Date: 08 December 2020  
Our ref: 334078  
Your ref: 3/2020/0667

**Planning consultation: Change of use and conversion of former fish hatchery to three holiday let units and creation of associated car park for six vehicles.  
Location: Whitcher Well Fish Hatchery Whitendale Road Dunsop Bridge BB7 3BL**

#### **SUMMARY OF NATURAL ENGLAND'S ADVICE**

dwg. no.	5891 c/b/01	date	Apr-20	rev	D
----------	-------------	------	--------	-----	---

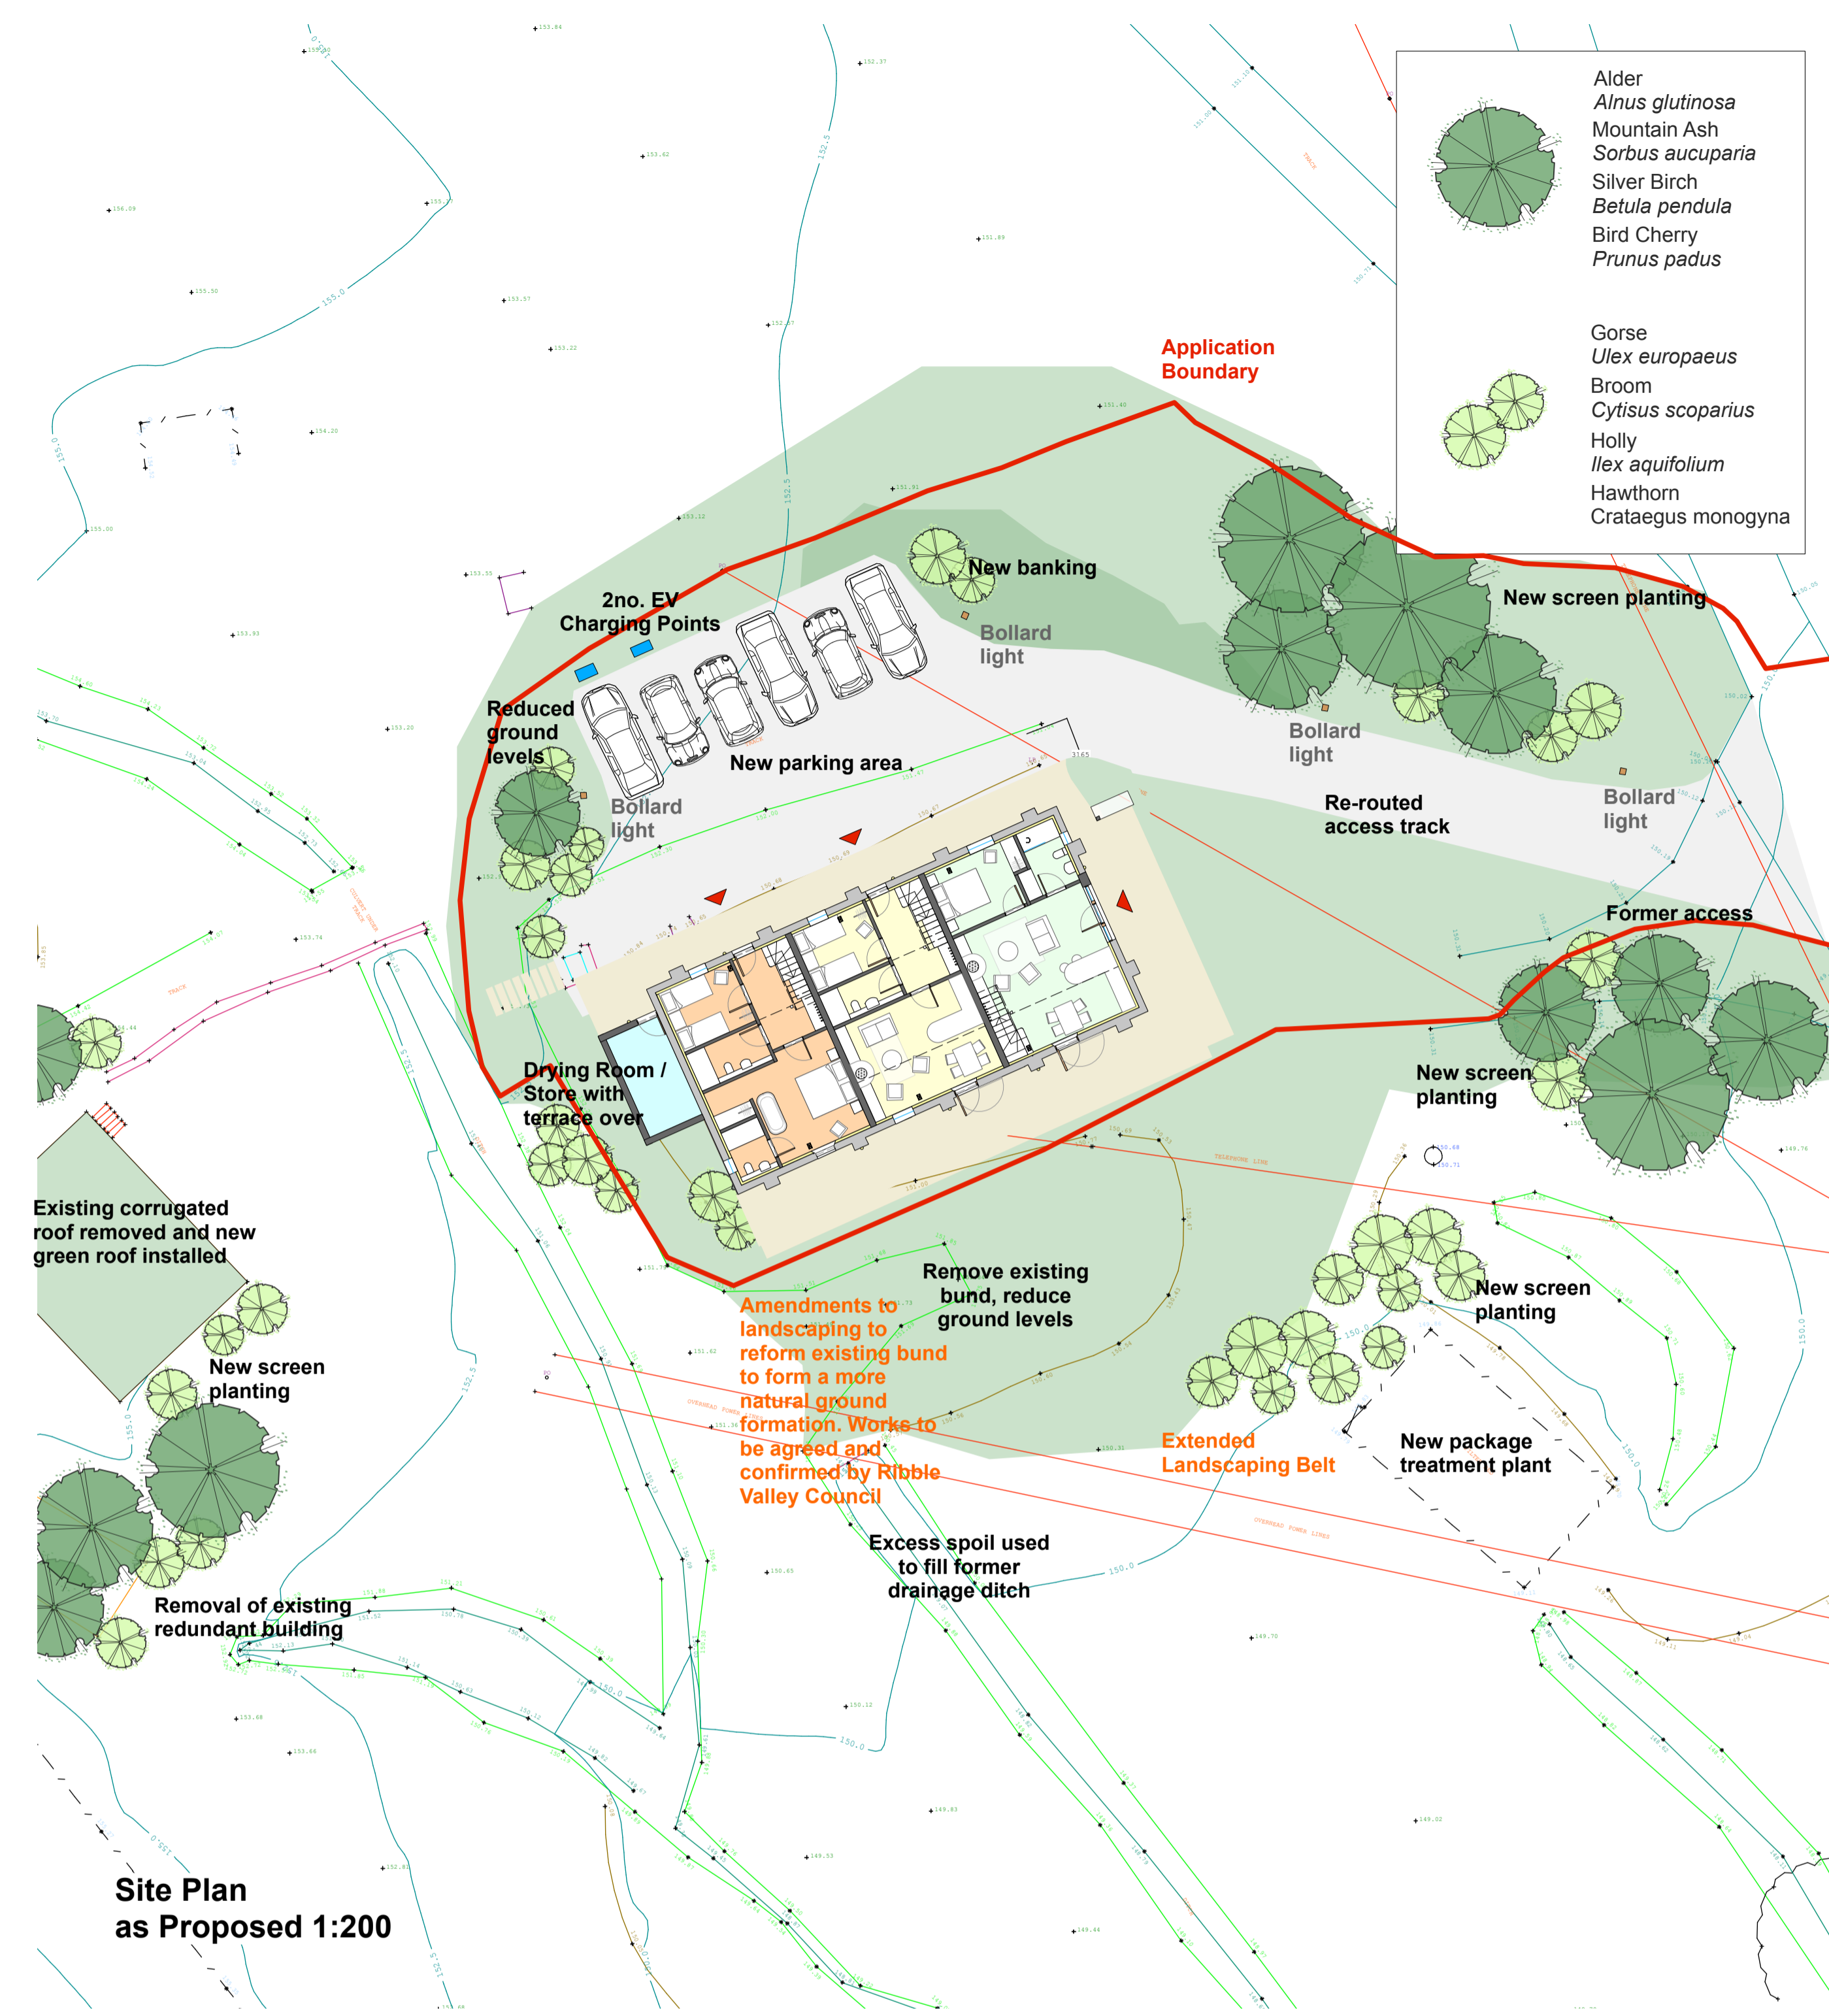
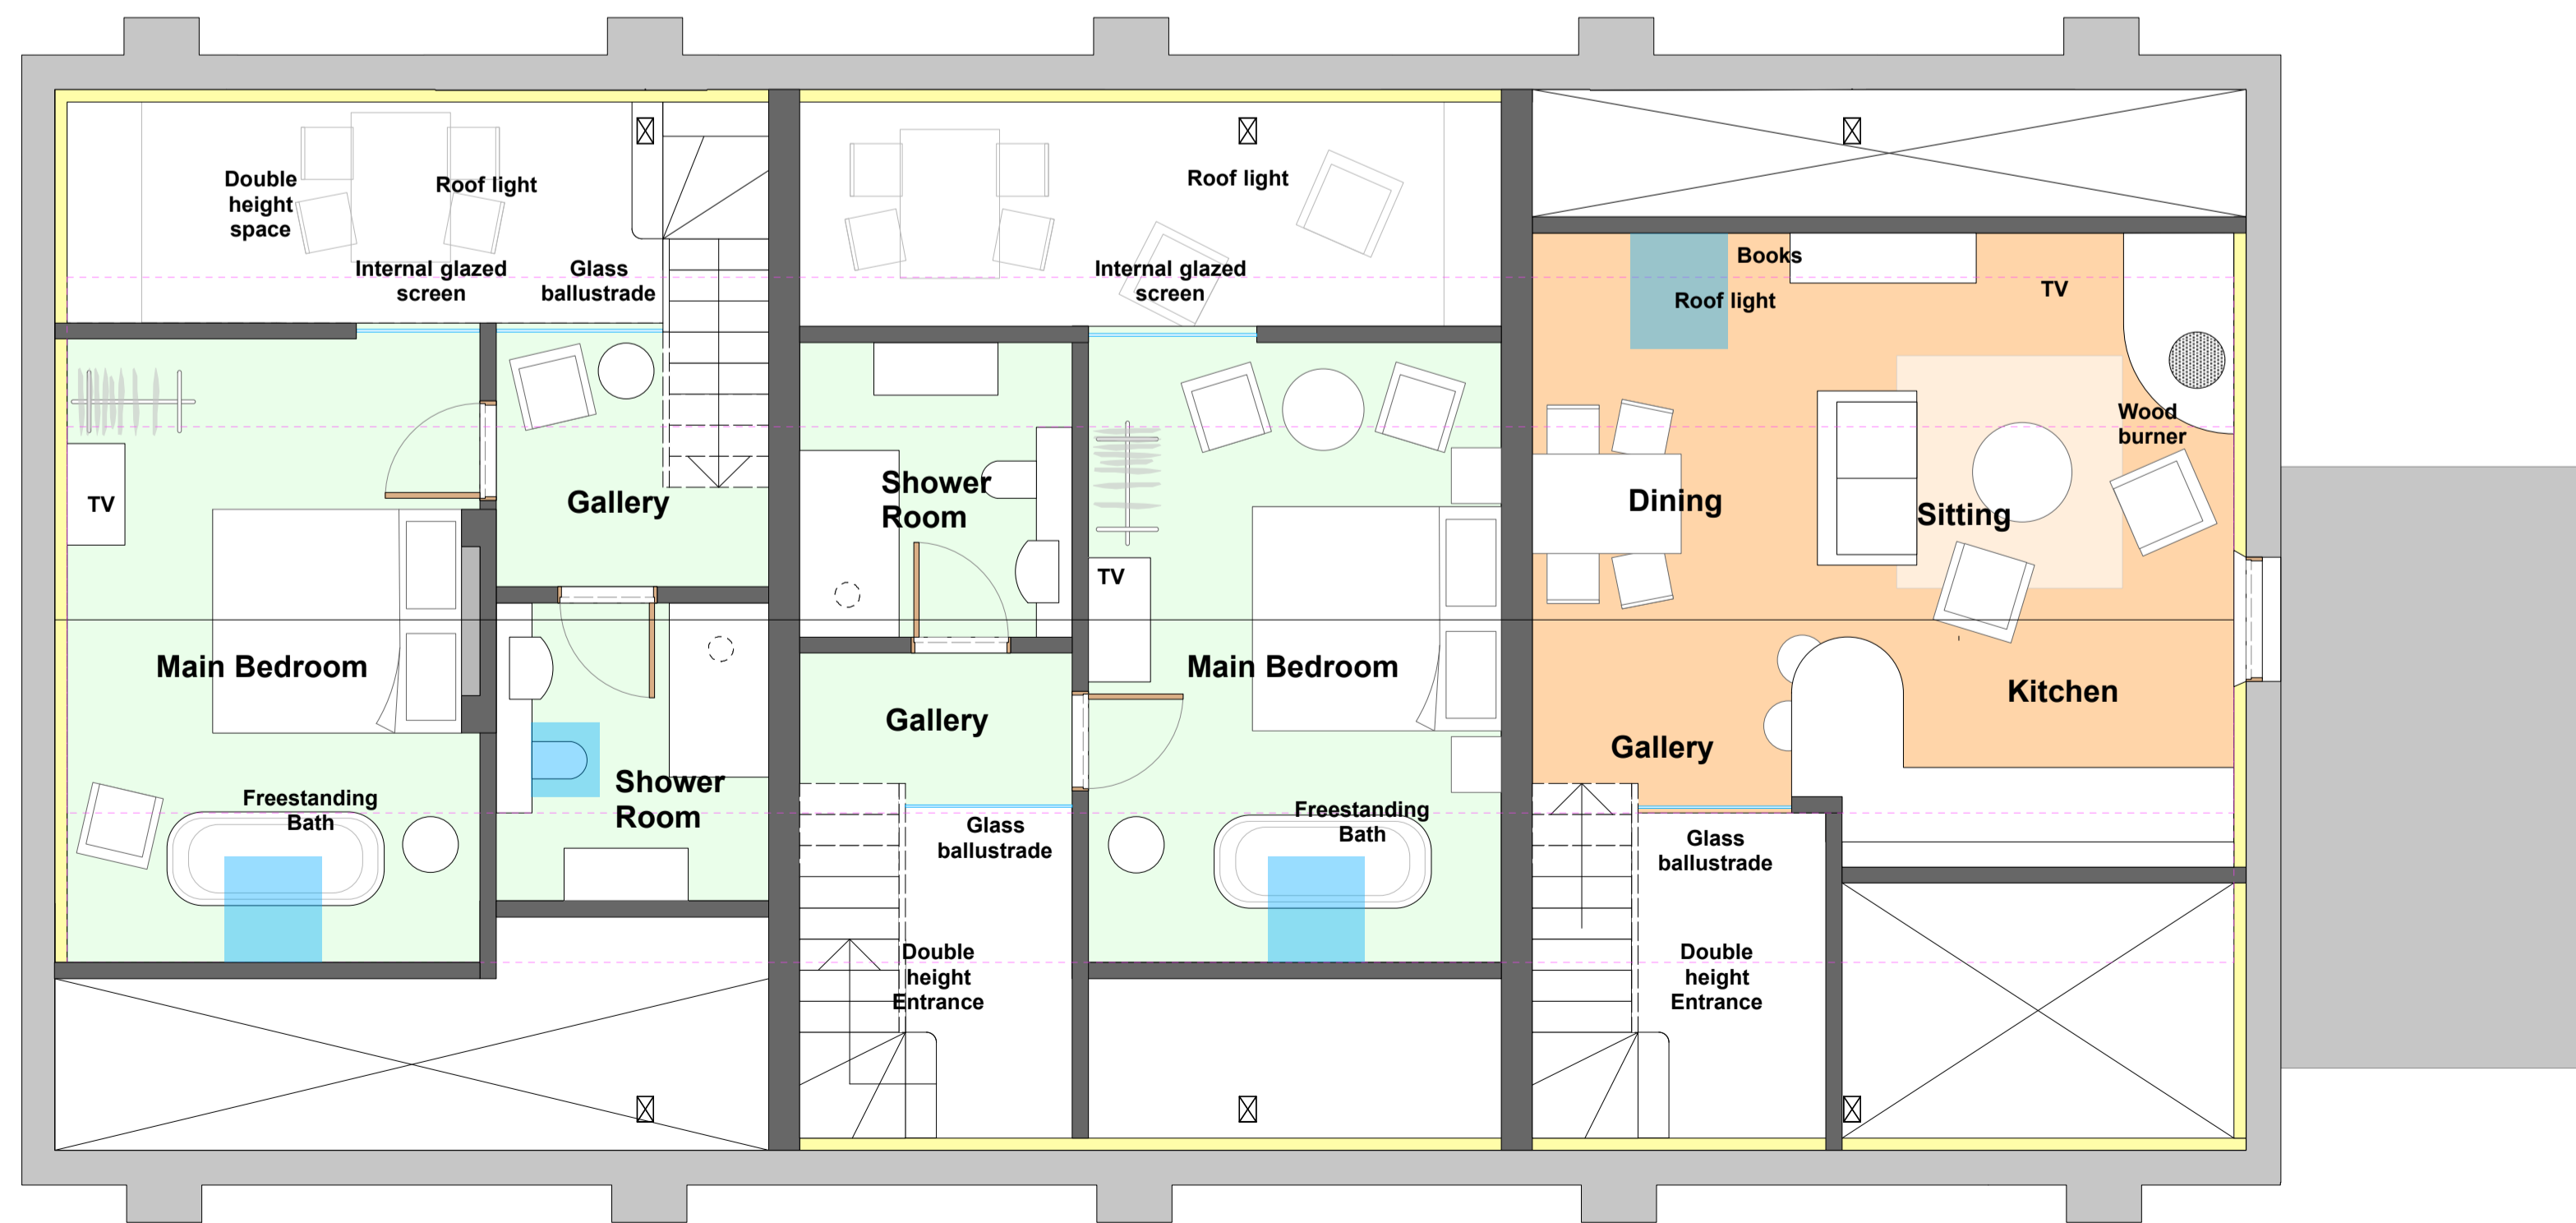
Detailed plans need to be submitted to show the proposed planting and how this will help to mitigate the landscape impacts along with site sections showing the impact of the proposed land lowering.
